CITY OF ALBUQUERQUE

**Re: San Clemente Apartments Buildings E and F,
200 and 202 San Clemente Ave NW, Traffic Circulation Layout
Engineer's Stamp dated 10-12-12 (G14-D006A)**

TRAFFIC CIRCULATION LAYOUT

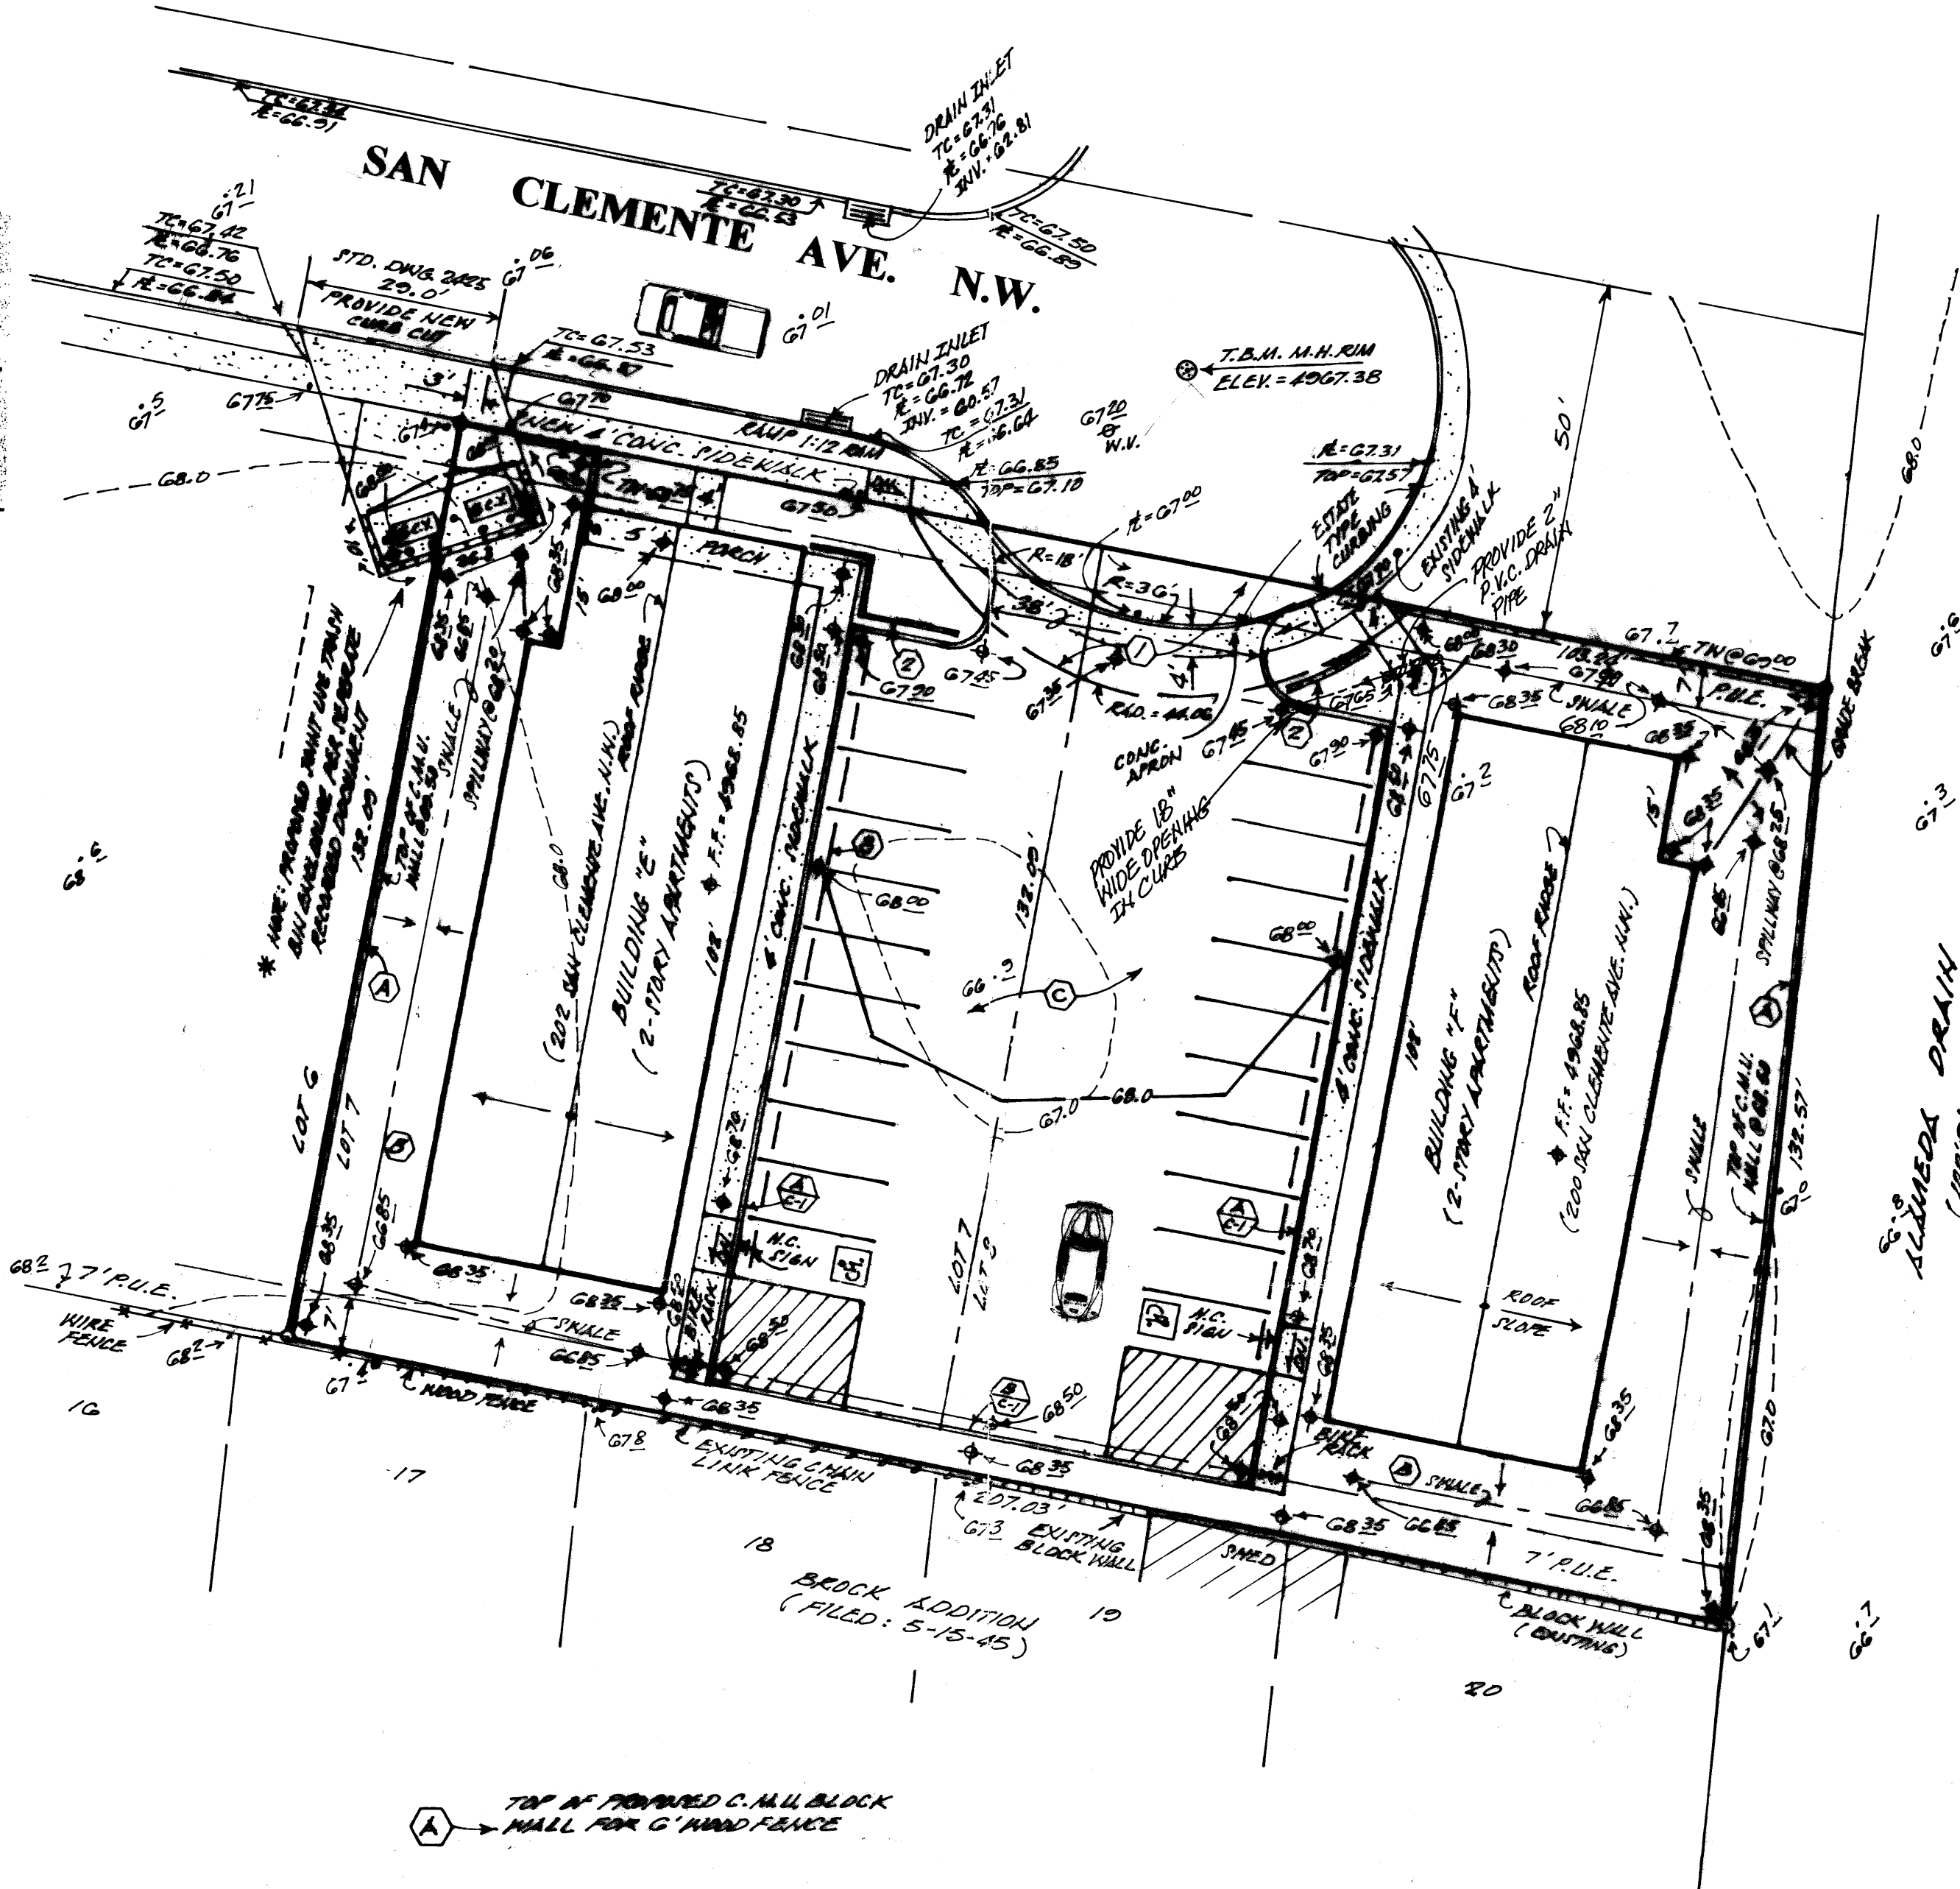
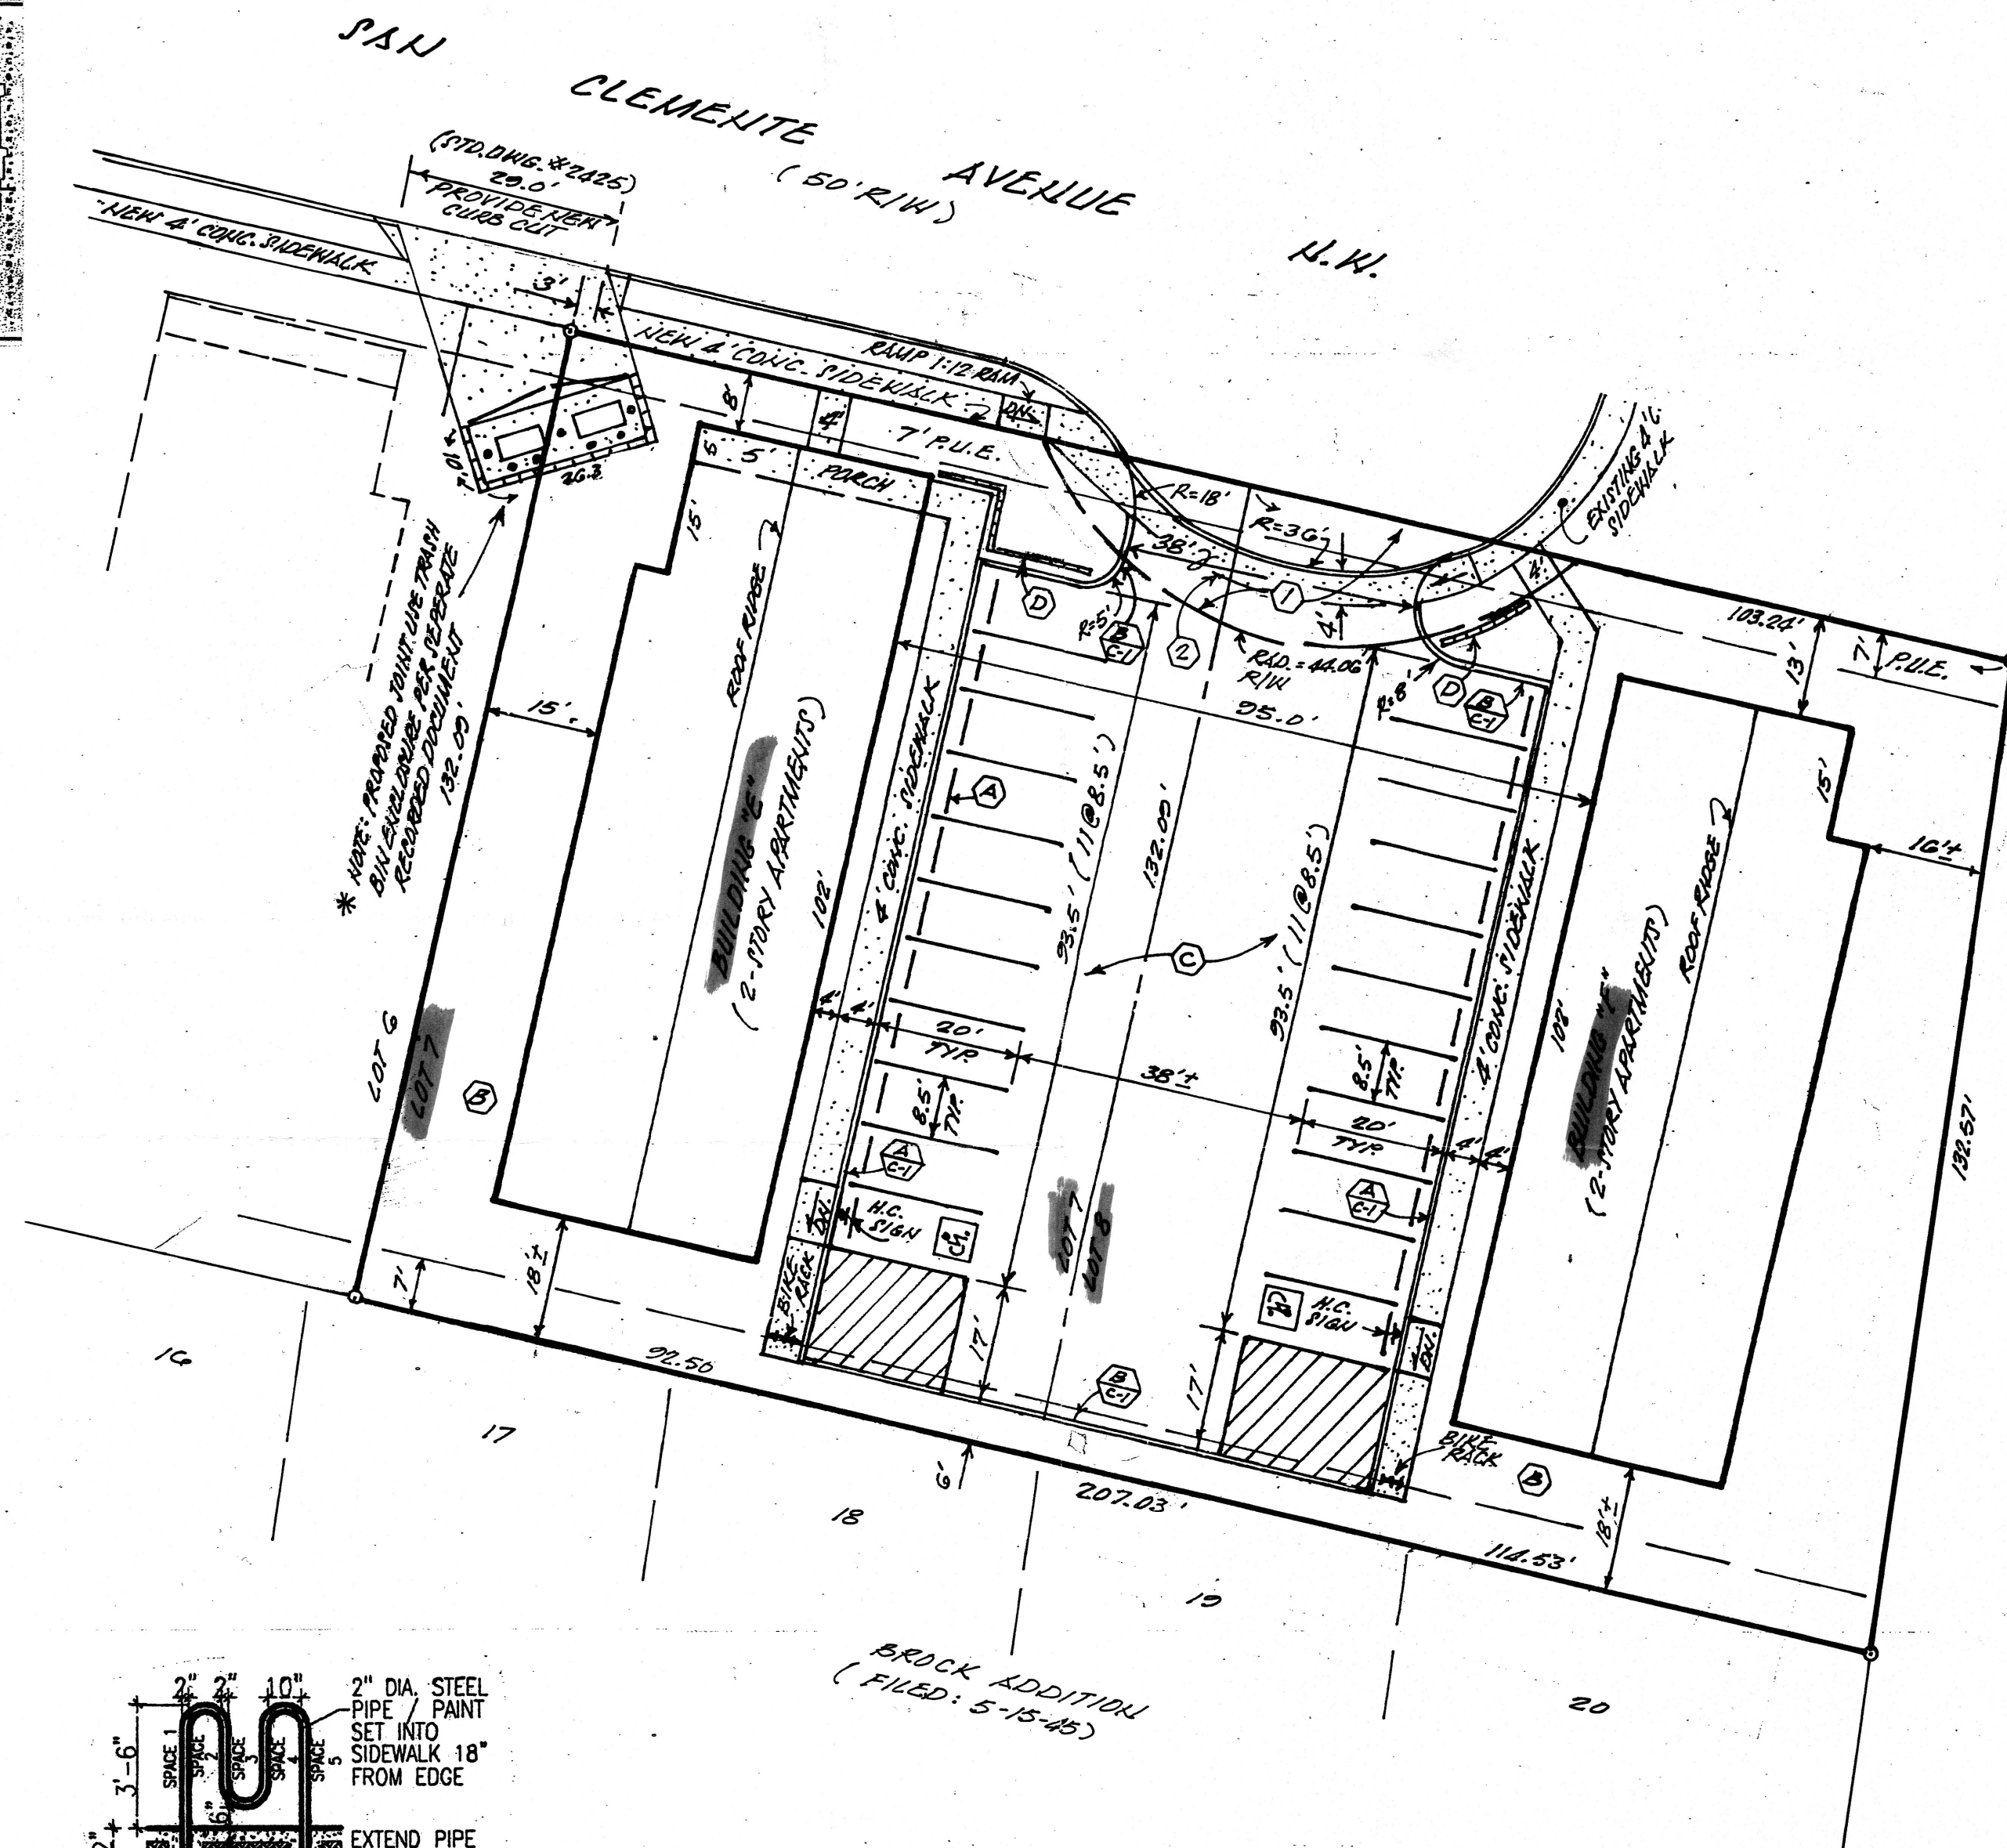
1. The proposed 3-foot high screen wall (keyed note D) appears to interfere with the sight distance for the entrance. Provide a sight distance exhibit. Please note that walls, trees, and shrubbery over 3 feet tall (measured from gutter pan) will not be acceptable in this area.
2. Keyed note 1 indicates additional right of way is to be dedicated for this site. This requires a platting action. Please provide a timeline for this replat. A preliminary plat must be approved prior to building permit approval.
